From: Mundy, Ben - Oxfordshire County Council <Ben.Mundy@Oxfordshire.gov.uk>  
Sent: 16 October 2023 11:00  
To: DC Support; Clancy Sloan  
Cc: Transport CDC Minor; Cllr Ian Corkin  
Subject: 23/01292/F Dairy Cottage, Main Street, Wendlebury, Bicester, OX25 2PR

**Planning Application:** 23/01292/F

**Location:** Dairy Cottage, Main Street, Wendlebury, Bicester, OX25 2PR

**Description:** Variation of Condition 2 (plans) of 21/01664/F - revised plans

Drawing Title:
Garage Plans & Elevations

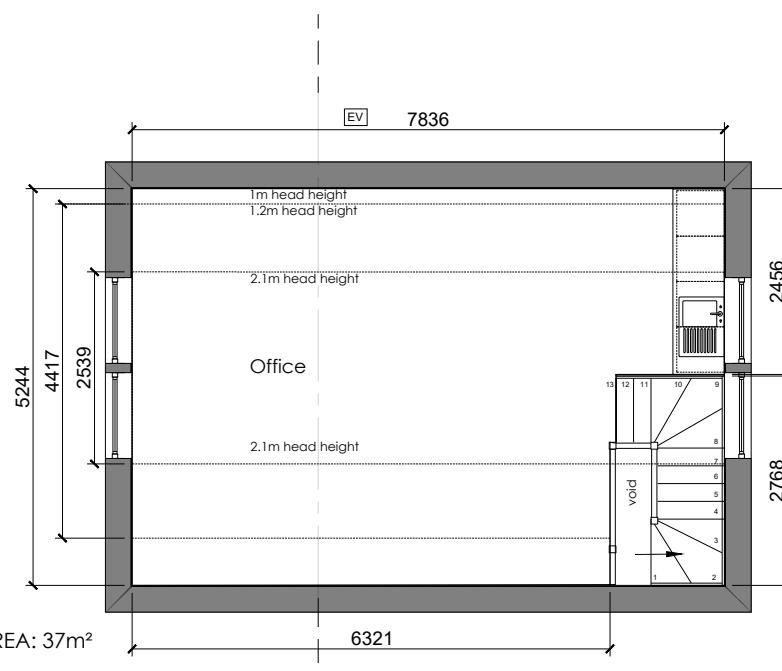
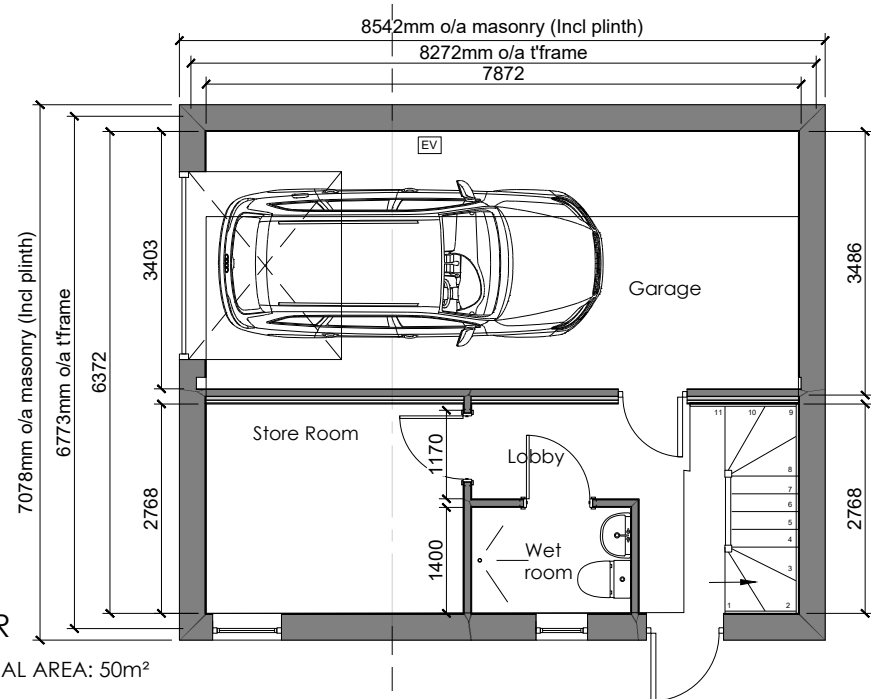
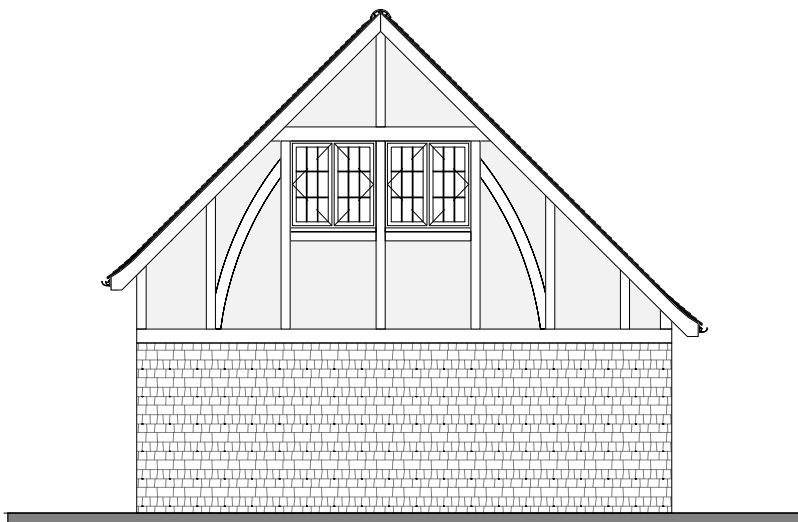
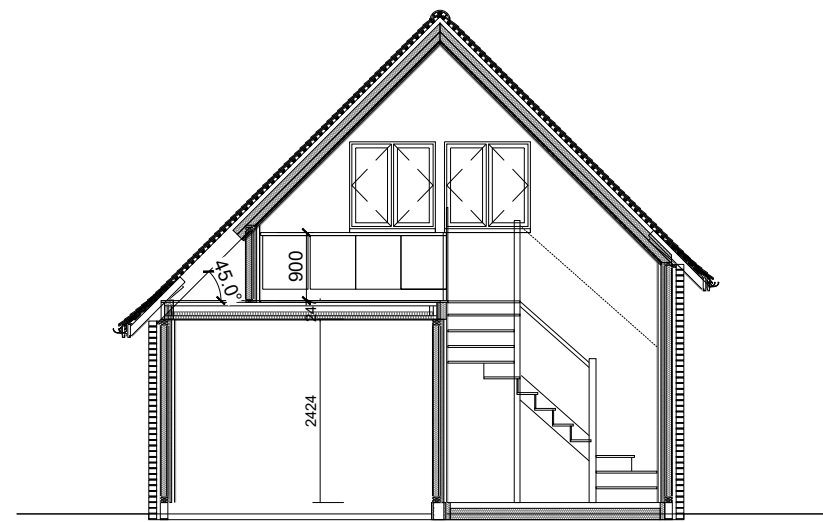
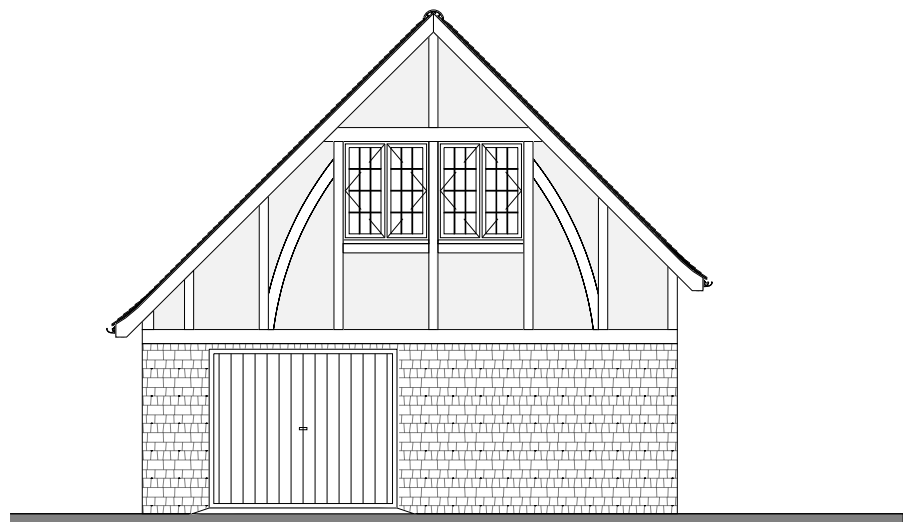
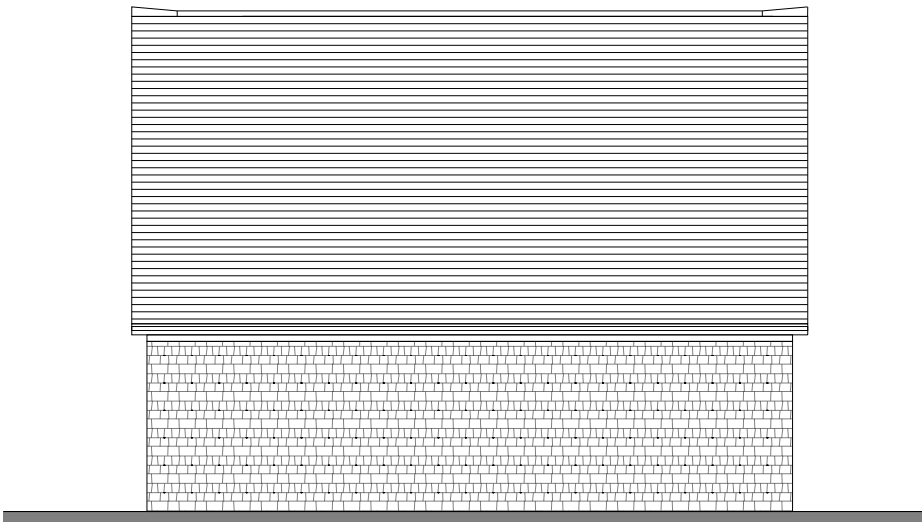
The revised plans have incorporated a garage that is suitable in scale to park one vehicle. There is also sufficient driveway space to park additional vehicles and which allows vehicles to manoeuvre and exit the site in forward gear.
